Land at Ford Airfield, Ford, West Sussex

IRM (F/14/24/RES)

Design Advisor response, prepared on 28th January 2024

Ryebank Park Basin Sections
Ryebank Park 1 of 2

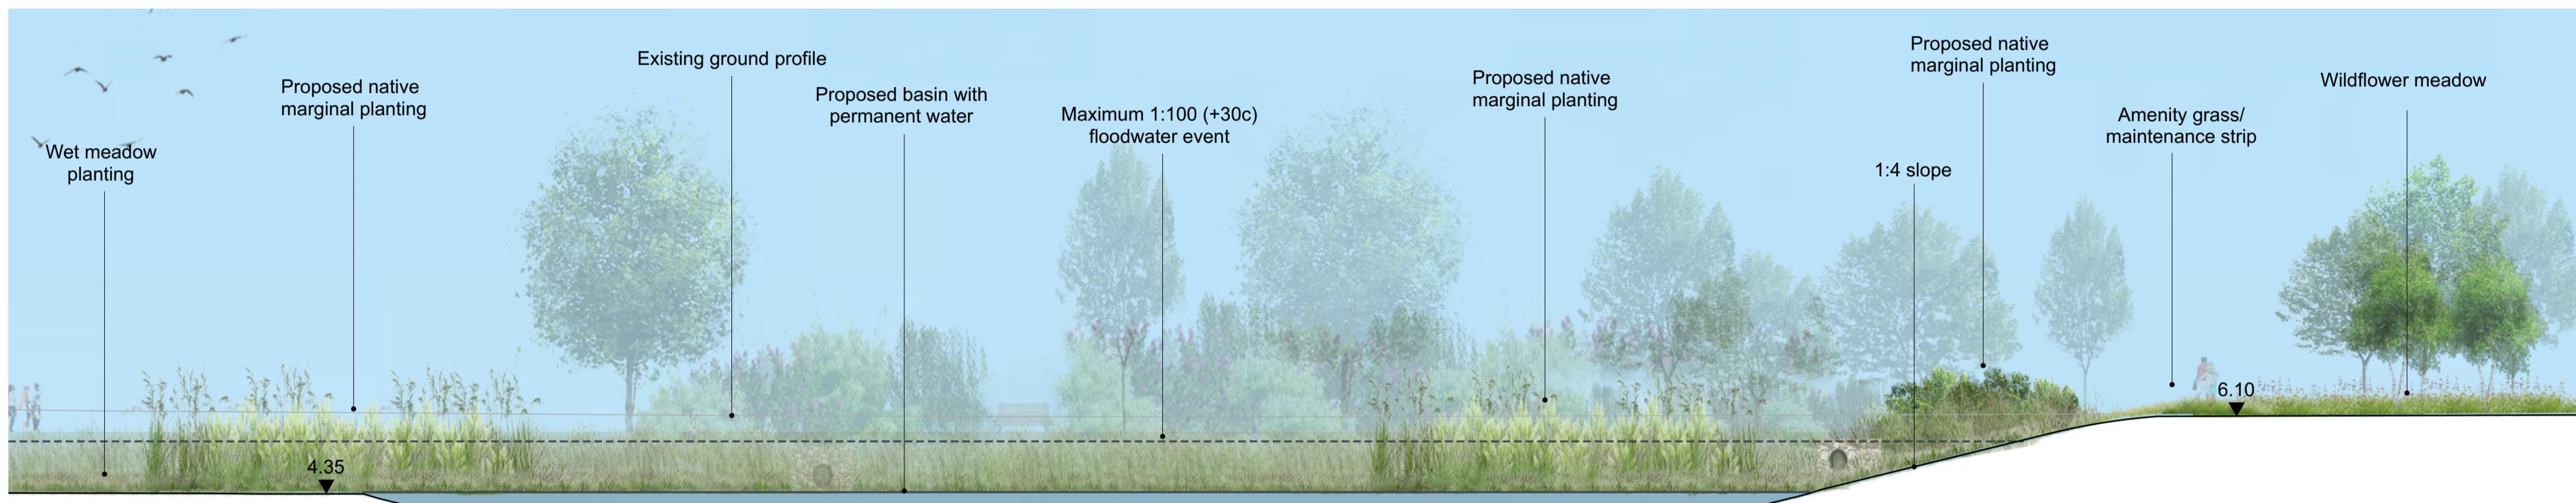
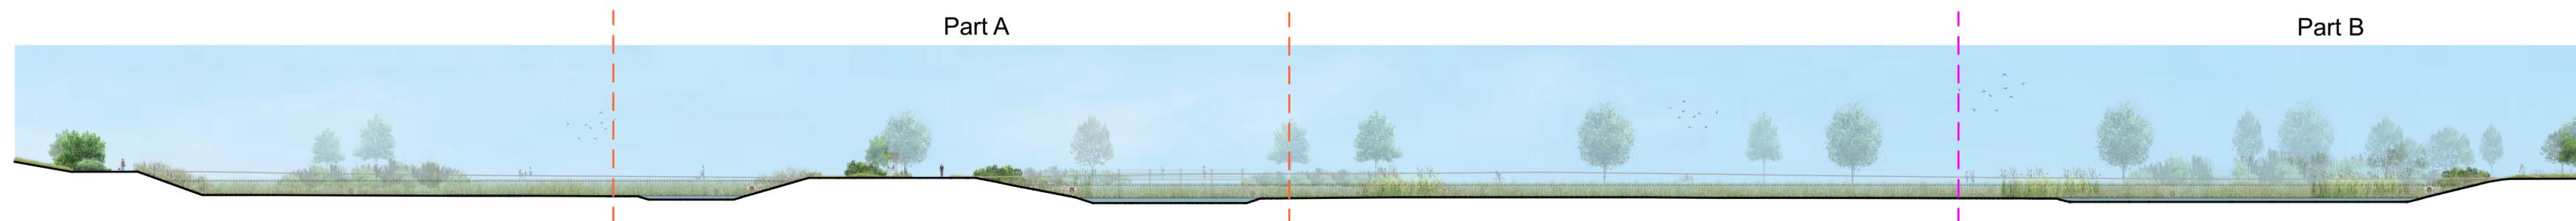
8	Through the elaboration of the layout, I have maintained a concern for the impact of attenuation basins in Ryebank Park. The basins at Landings Green don't dominate the space and consequently, it has been possible to shape these around the master plan. As such, the northern neighbourhood has an east-west flow that links across north-south circulation and landscape links. Conversely, the basins at Ryebank Park fully dominate the area and there is limited left-over space to shape or knit these into the layout (despite clear attempts to do so). For me, the impact of the proposed basins is such that the area cannot be used for any meaningful activity	<p>It is noted that the encroachment of development in RM4 reduces the amount of circulation space between the edge of the basin and the carriageway - this has been raised as a concern in response to RM4.</p> <p>Overall, the basins continue to have a dominating impact on the character of Ryebank Park and its value as an amenity space.</p> <p>While the illustrative layout in The Landings Master Plan Document did not intimate the dominance of basins in this area, it is acknowledged that the framework plan from the same document provides some indication of scale and impact.</p> <p>It is further acknowledged that some attempt has been made to mitigate the physical and visual impact of the basins through the landscape design.</p>	No

9	Connected to the previous comment, there is a concern for the safety and experience of circulation around and between basins. The below section is an attempt to rescale the application plan to understand the character of a link between basins. From this, it appears akin to walking along a 5/ 6m ridge, with 1:3/ 1.35 drop on each side.		
10	The requirement for basins is acknowledged. Also, the need to reduce constrained space and the existence of the open space parameter plan is acknowledged. However, the consequential
